DEVELOPMENT REVIEW BOARD – SPEED MEMO

DRB CASE NO: 1009239

16
CITY OF ALBUQUERQUE
PLANNING DEPARTMENT
May 9, 2012
DRB Comments

RE: Lot 12-A, Block 5, J.W. Van Cleave Homestead Addn.

SITE SKETCH
LOT 12-A-1 & 12-A-2
J.W. VAN CLEAVE HOMESTEAD ADDITION
LOT 12-A, BLOCK 5
CITY OF ALBUQUERQUE

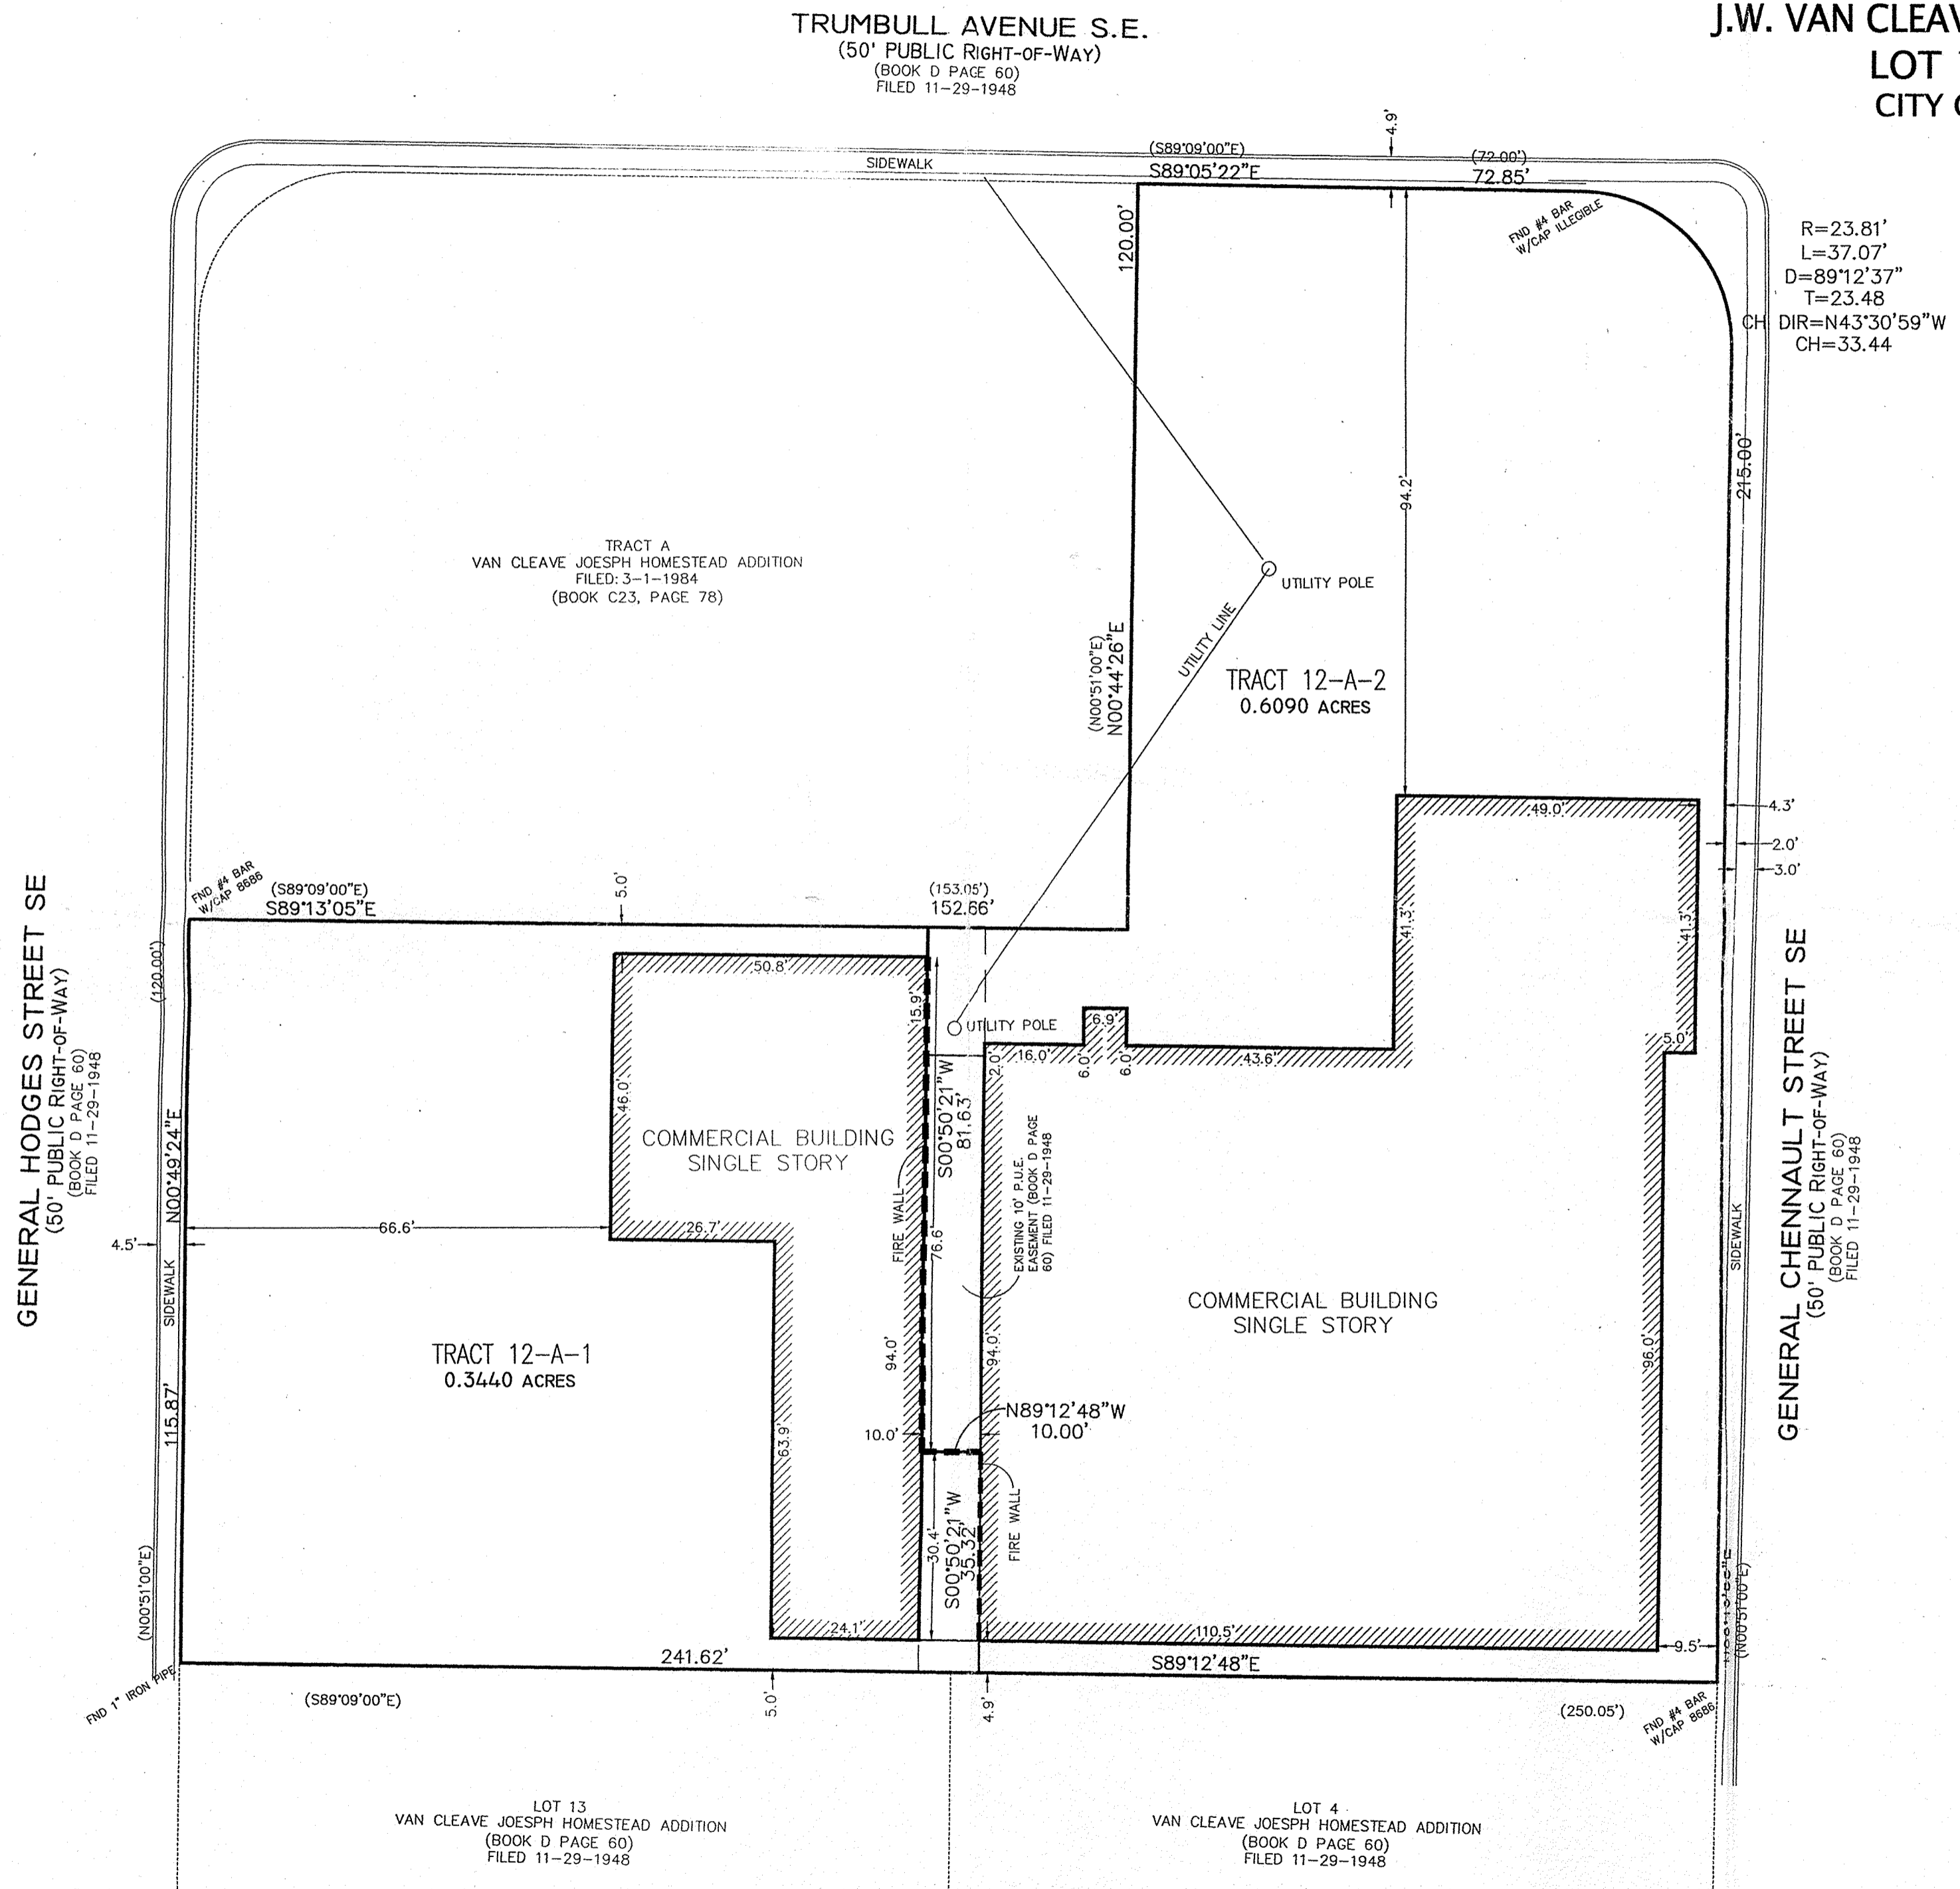
Each proposed lot must demonstrate that Zoning Code parking requirements are met on on-site (on each proposed lot) prior to plat approval – this requires calculations and a parking lot layout consistent with the parking standards of the Development Process Manual.

Additionally, a licensed engineer or architect must verify that the buildings meet the code requirements based on proposed lot lines (10 foot setback and zero setback).
